PHOTOMETRIC PLAN

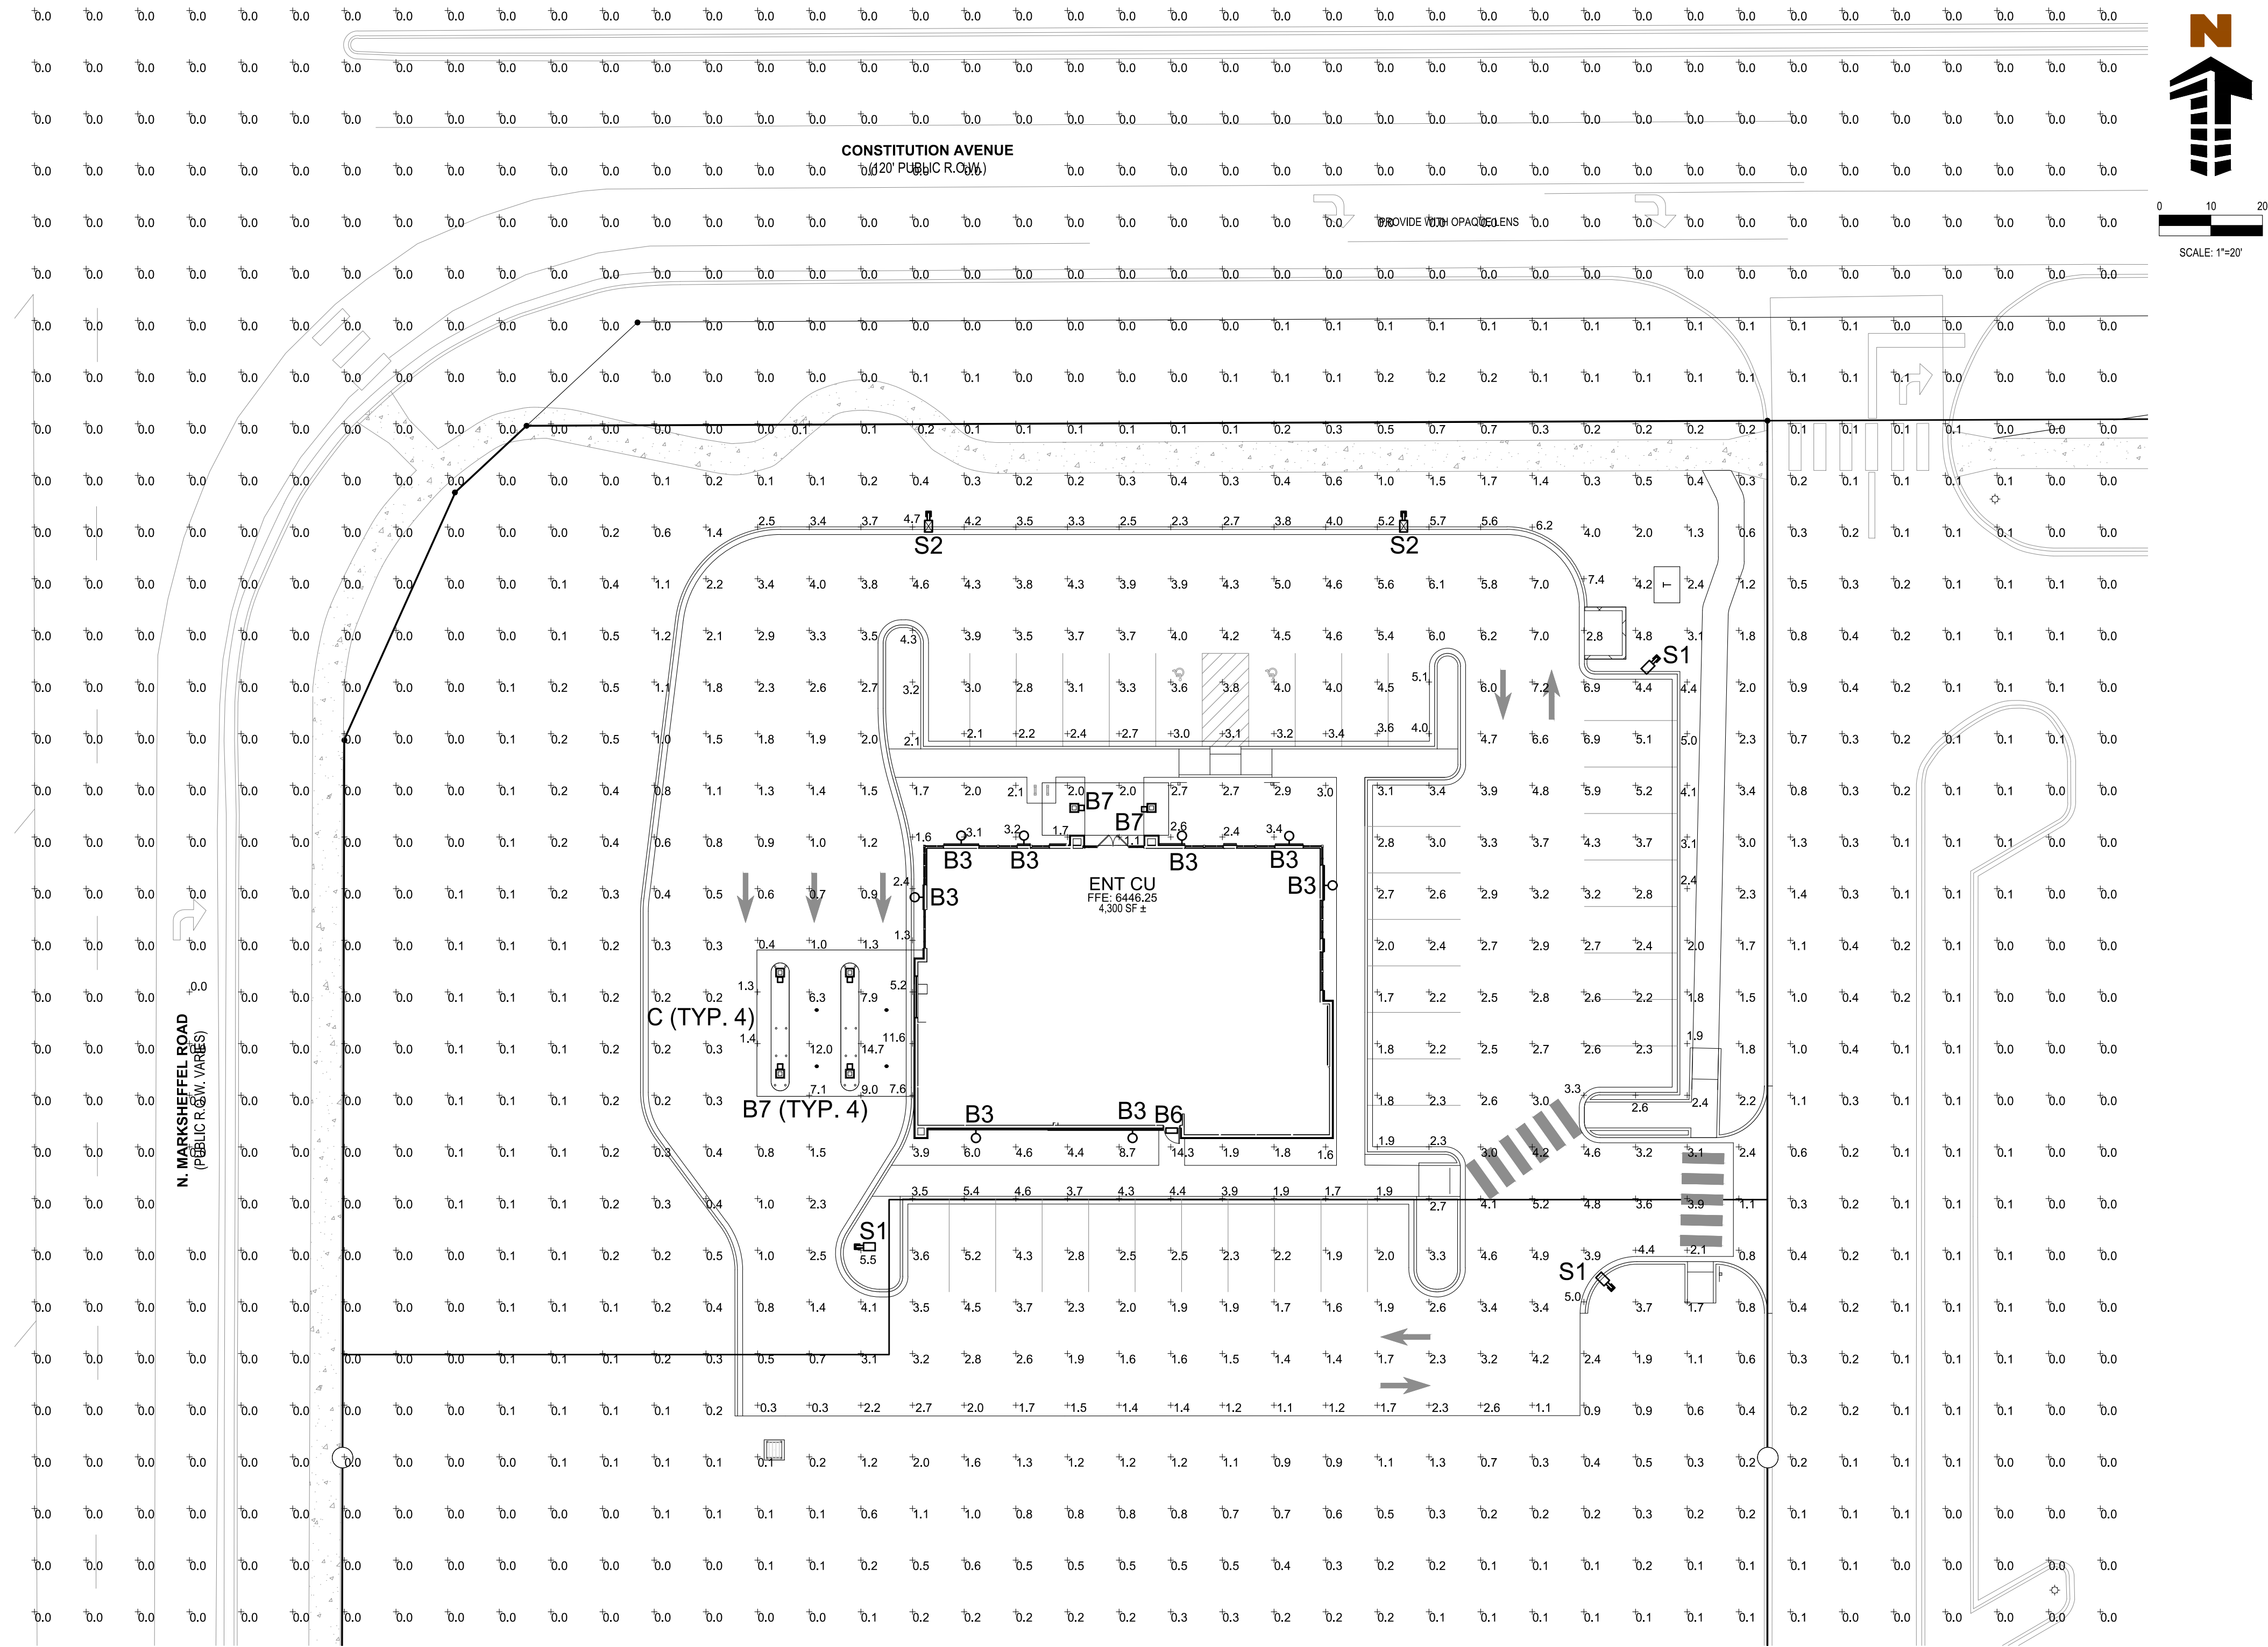
Update this to be consistent with the lighting plan.

Update this to be consistent with the lighting plan.
